RE: DFT Review Comments for Route 66 Flats (7600 Central Ave SW)
Project Number: PR-2024-009904

On behalf of High Desert Housing and BlueLine Development, thank you for your Site Plan review of the new affordable housing community located at 7600 Central Avenue SW.

Please see the attached comment responses to Plan Review #1, if there are any questions pertaining to the responses, please let us know- Thank you Ed Parcell.

SITE AREA:	2.38 ACRES (103,679 SF)
BUILDING FOOTPRINT:	14,068 SF
PARKING/ DRIVE LANES:	26,940 SF
DETENTION / WQ:	10,080 SF
OPEN SPACE PROVIDED:	52,591 SF
<b>OPEN SPACE REQUIRED:</b>	<b>10,860 SF</b>
1-BEDROOM / 225 SF	10,575 SF
2-BEDROOM / 285 SF	285 SF

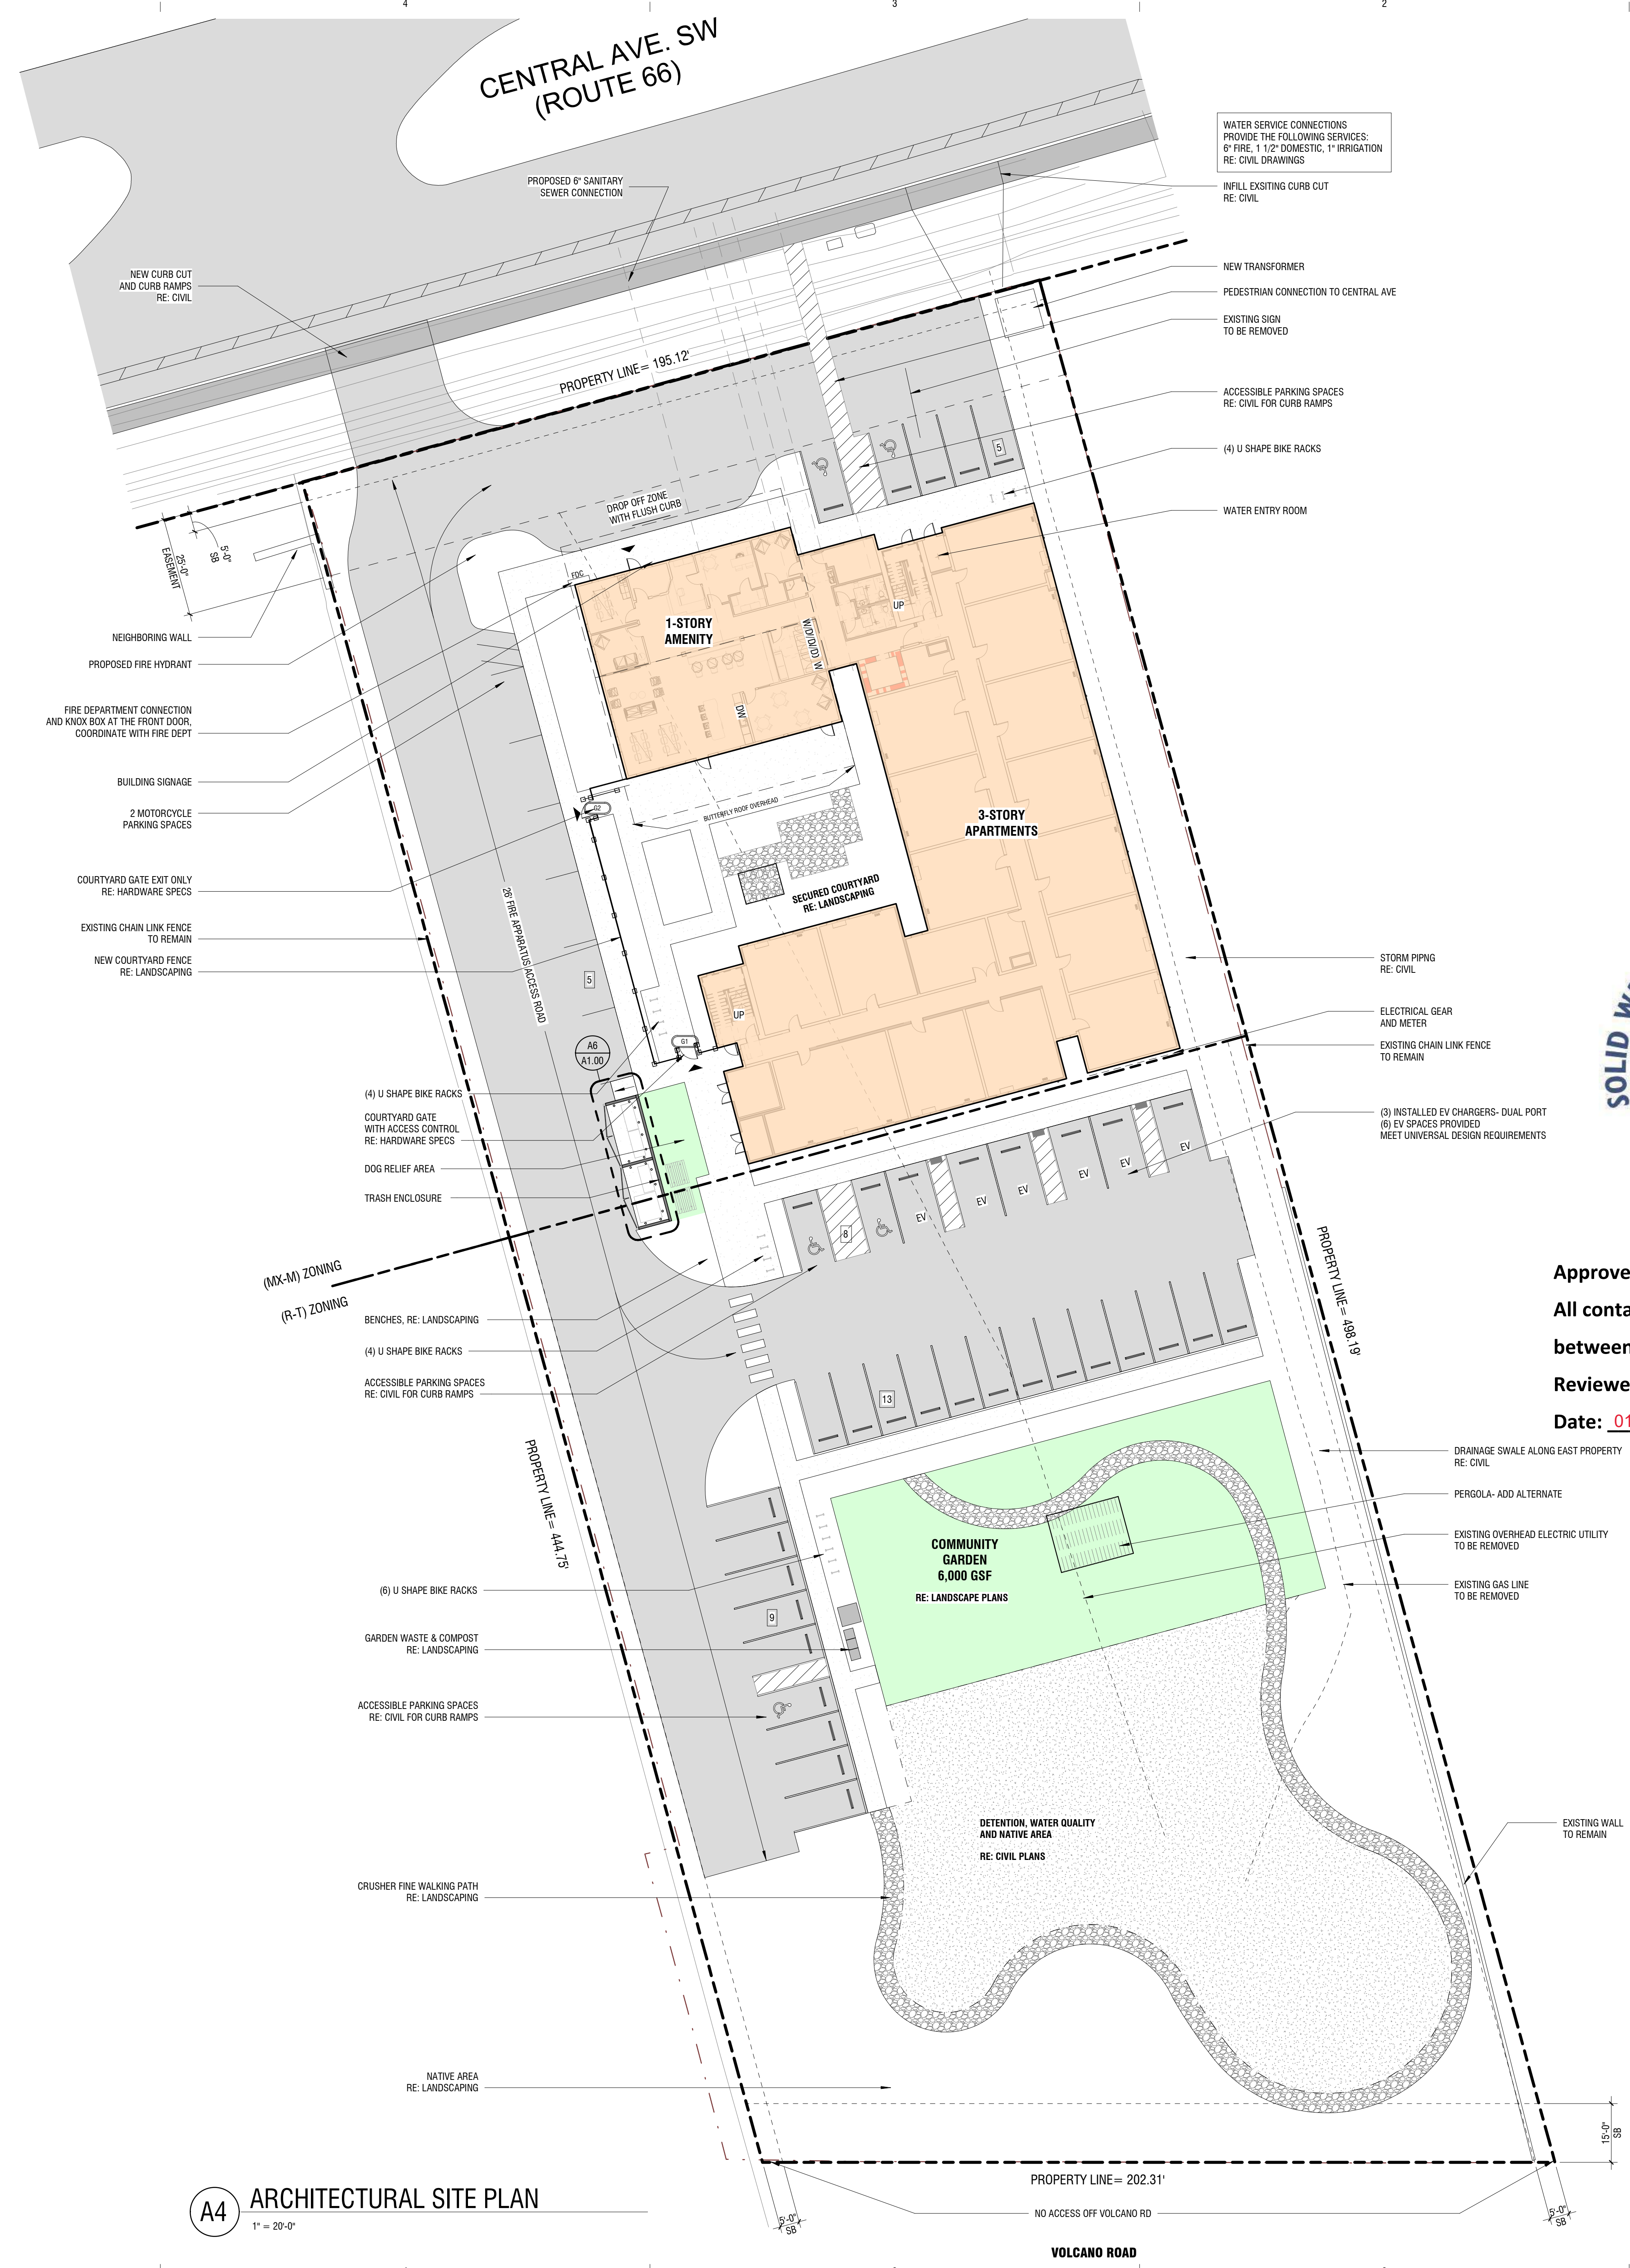
- a. Provide a utility plan or Civil Drawings that indicates the location of proposed services.
- b. Show existing public water and public sewer mains and any associated easements on the utility plan.
- c. Dimension the public water and public sewer easements on the utility plan.

(Wooten response): Utility Plan provided, see sheet C-300.
